Summary of the attached document titled "GNRSBP Reg. [REDACTED] Communication to PINS," authored by John Gray (PINS ID [REDACTED]), dated 10 December 2025.

From: John Gray, PINS ID number [REDACTED], PINS Case Reference: EN010162  
To: Planning Inspectorate  
Date: 10 December 2025  
Subject: Recreation Changes in Bathley and North Muskham  
(Community Orchard, Permissive Footpath 3)

Great North Road Solar and
Biodiversity Park
Environmental Statement

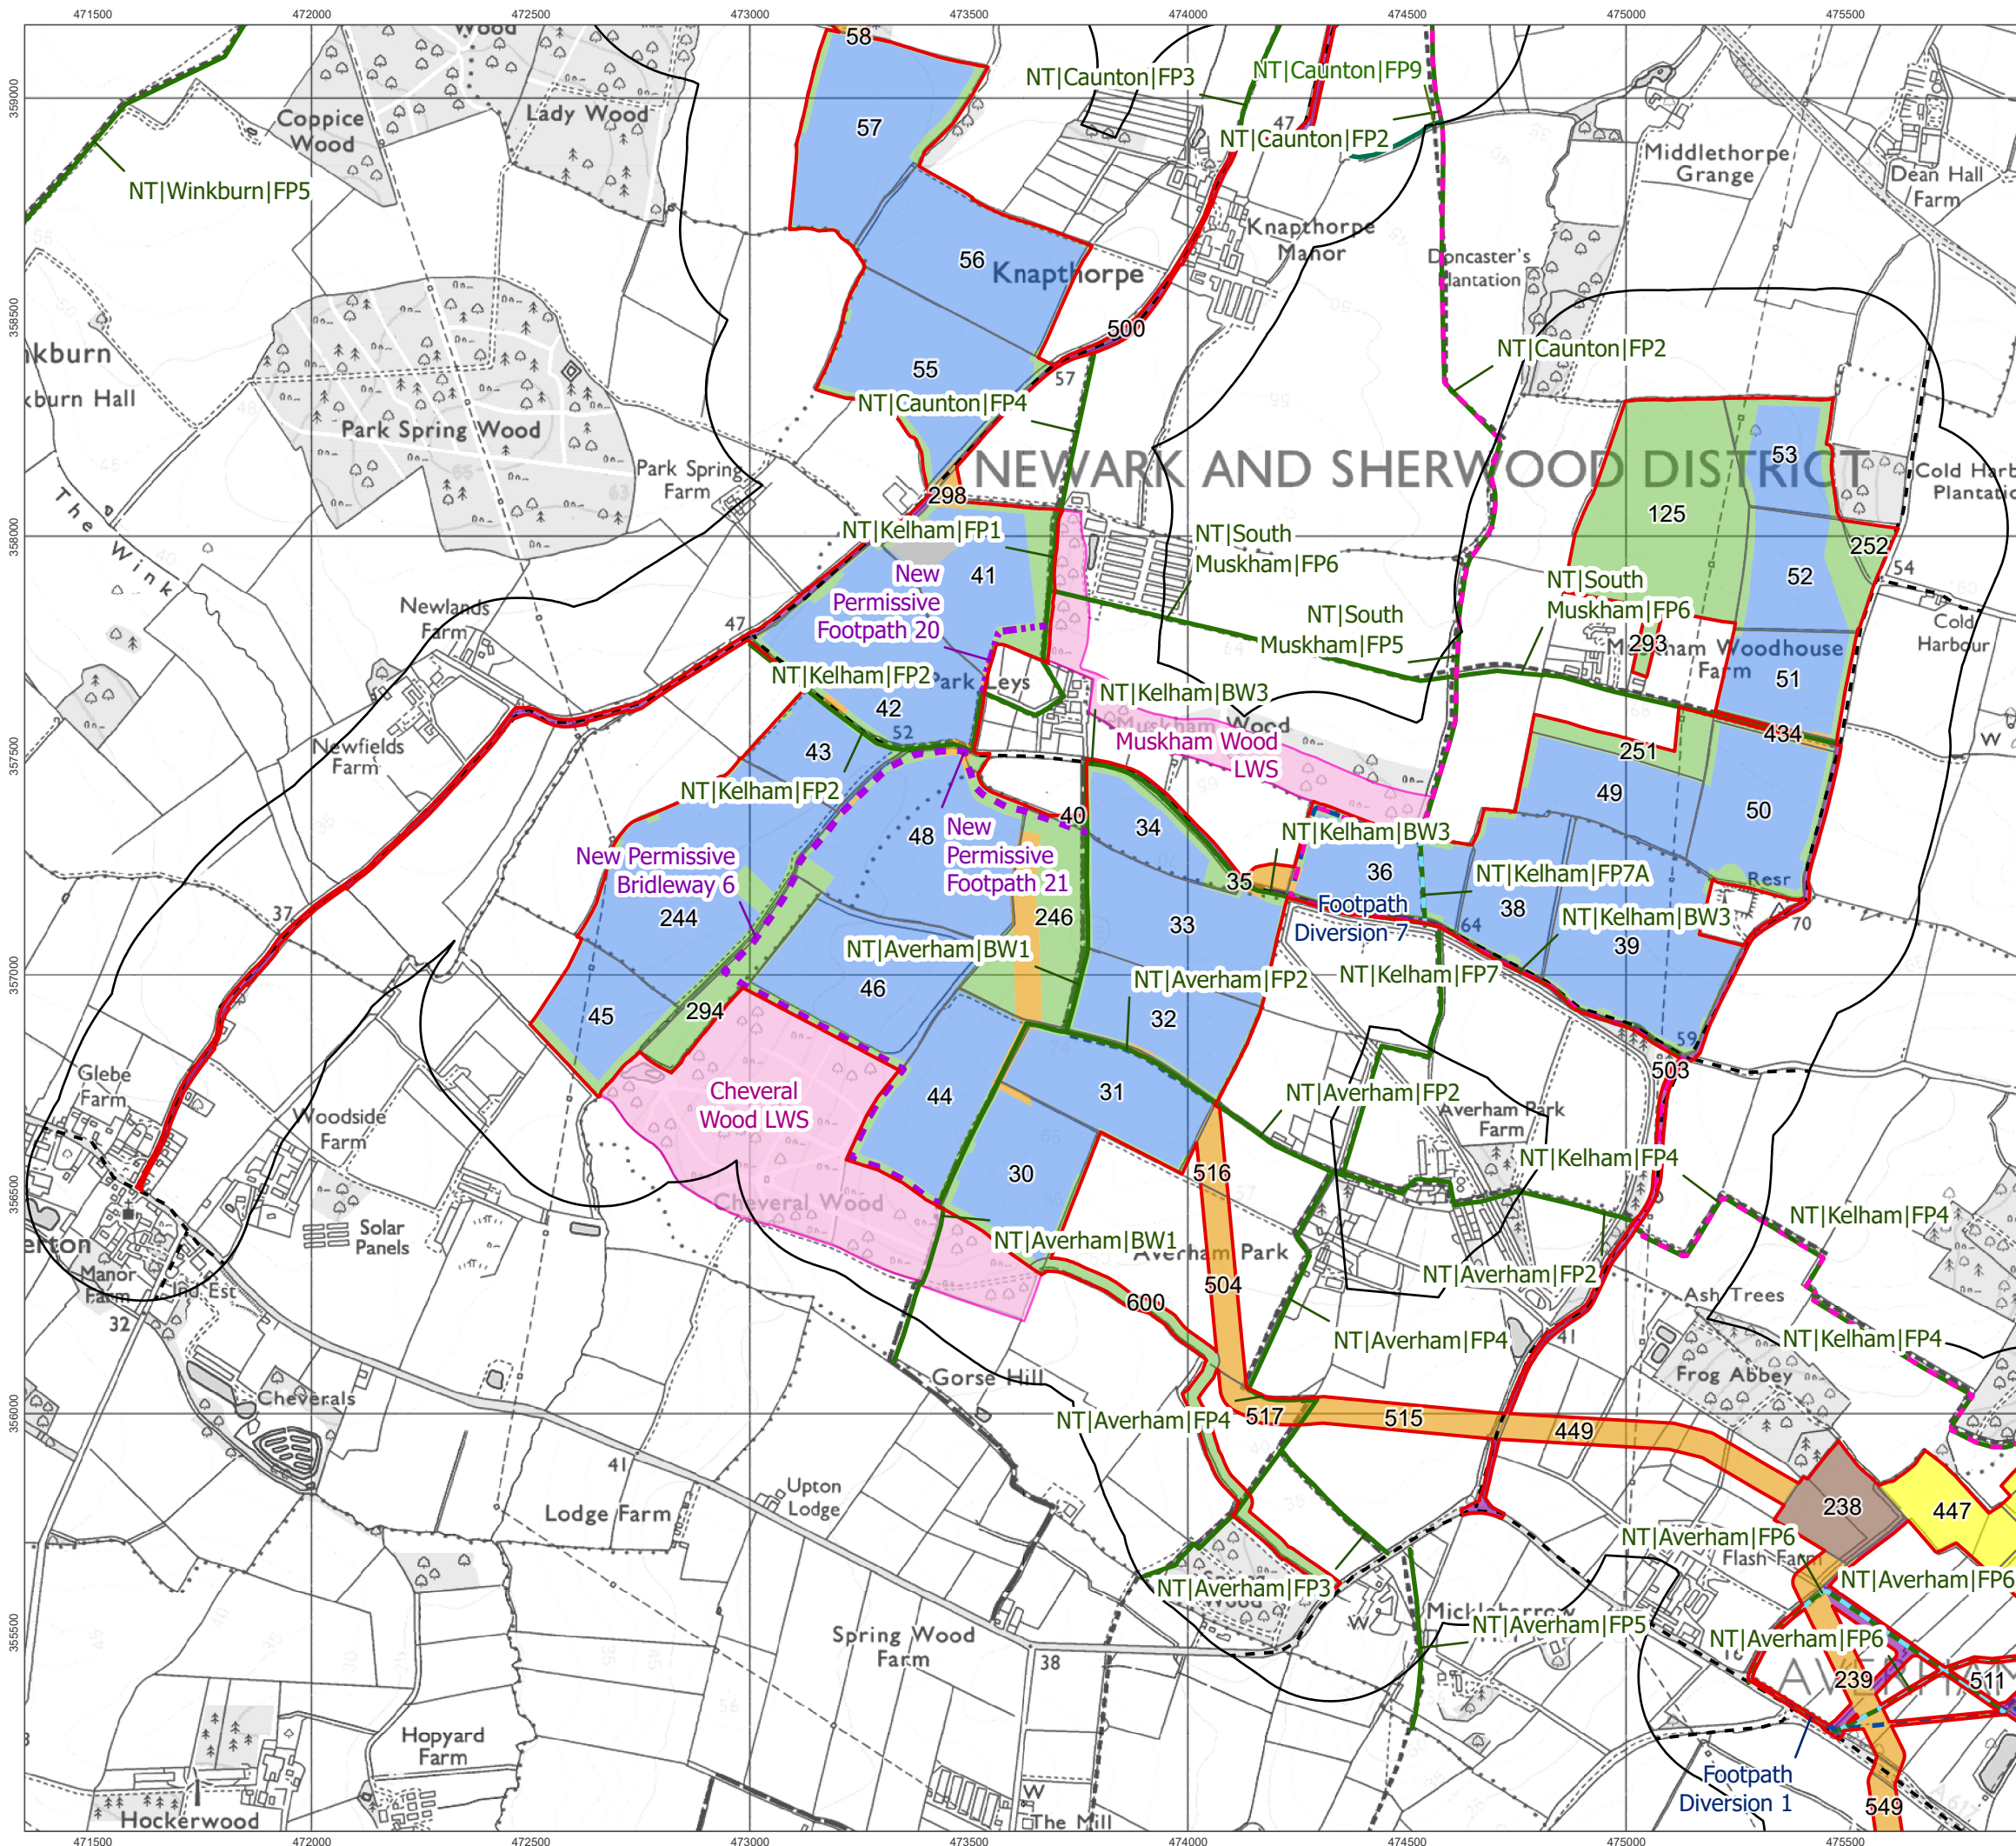
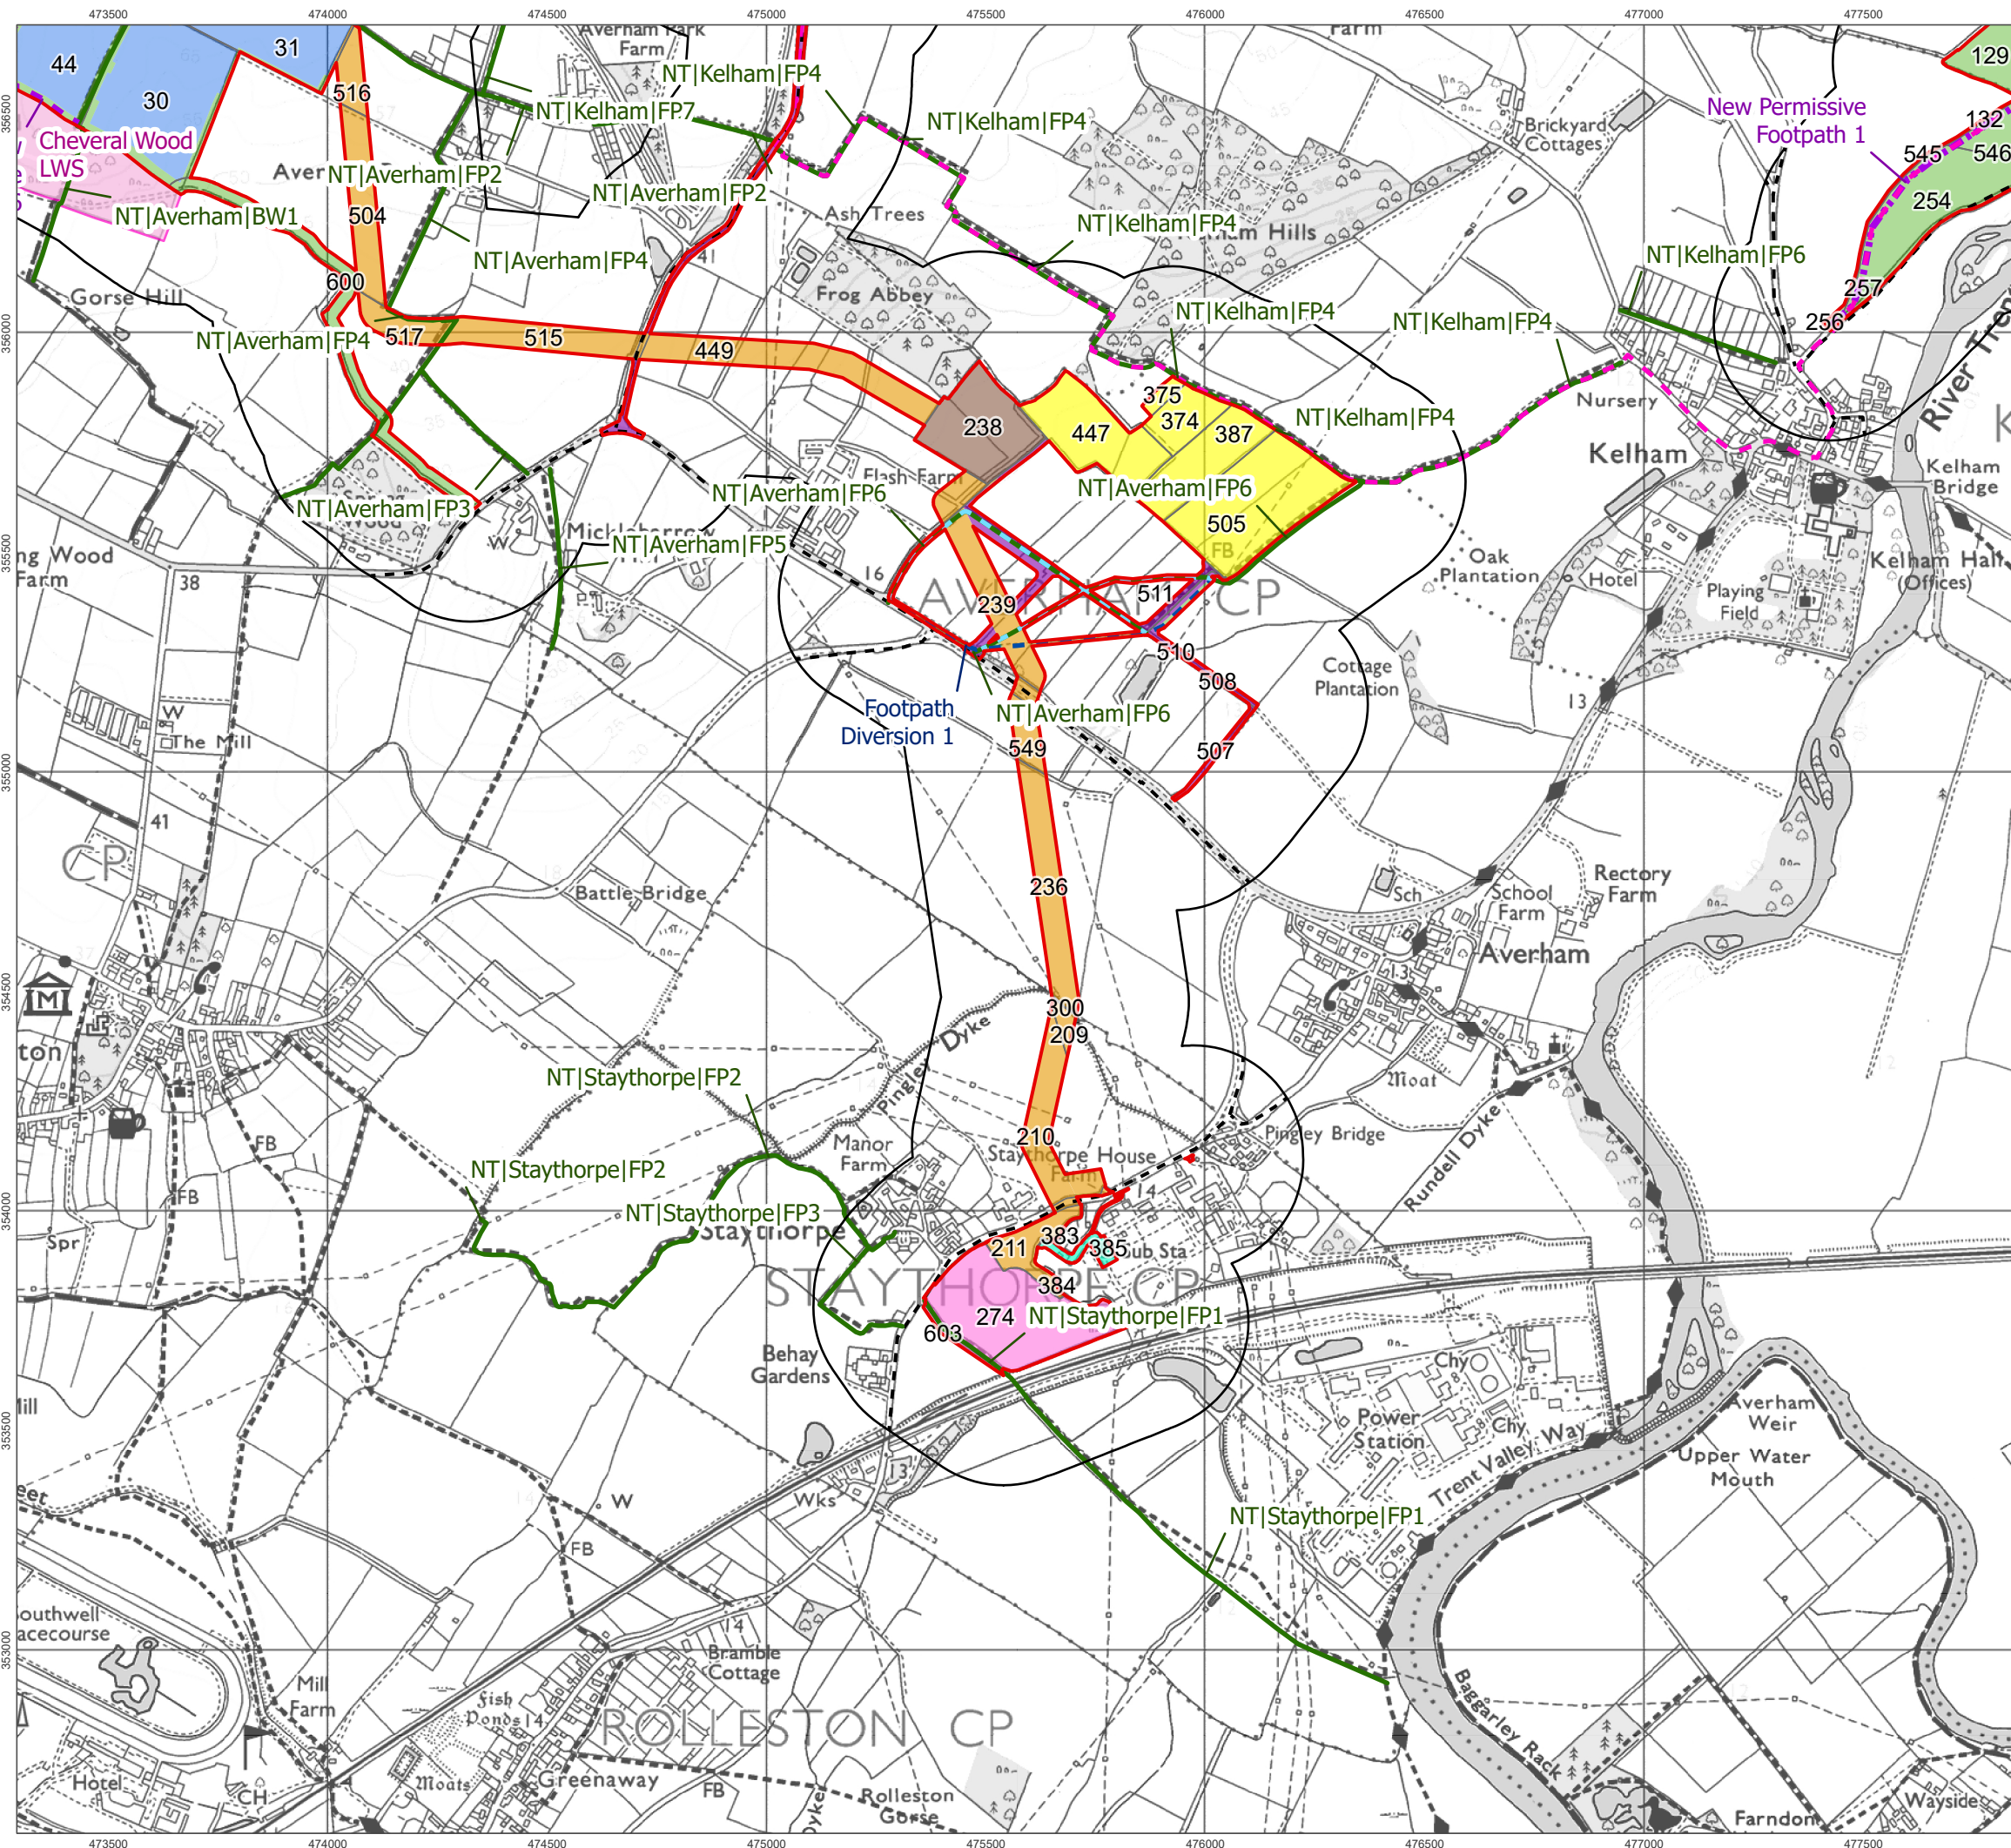
I write to ask that ExA consideration is given to issues arising from the two proposals labelled in Figure 1 Annotated extract of map from Elements Green's [APP-190,p.8] below.

Realigning the currently proposed PF3 route between B and C via point C+ would provide a minimum separation of 25m between PF3 and the pond; use an established (and dry) field track B-C+, and then follow a 60m new path along the southern edge of a minor dyke to rejoin the route at C.

***On the basis of several recent discussions with the resident I am persuaded that this realignment of Permissive Footpath 3 would protect the resident's conservation activities (and actually improve the route by avoiding the frequently very wet area immediately N of the pond).***
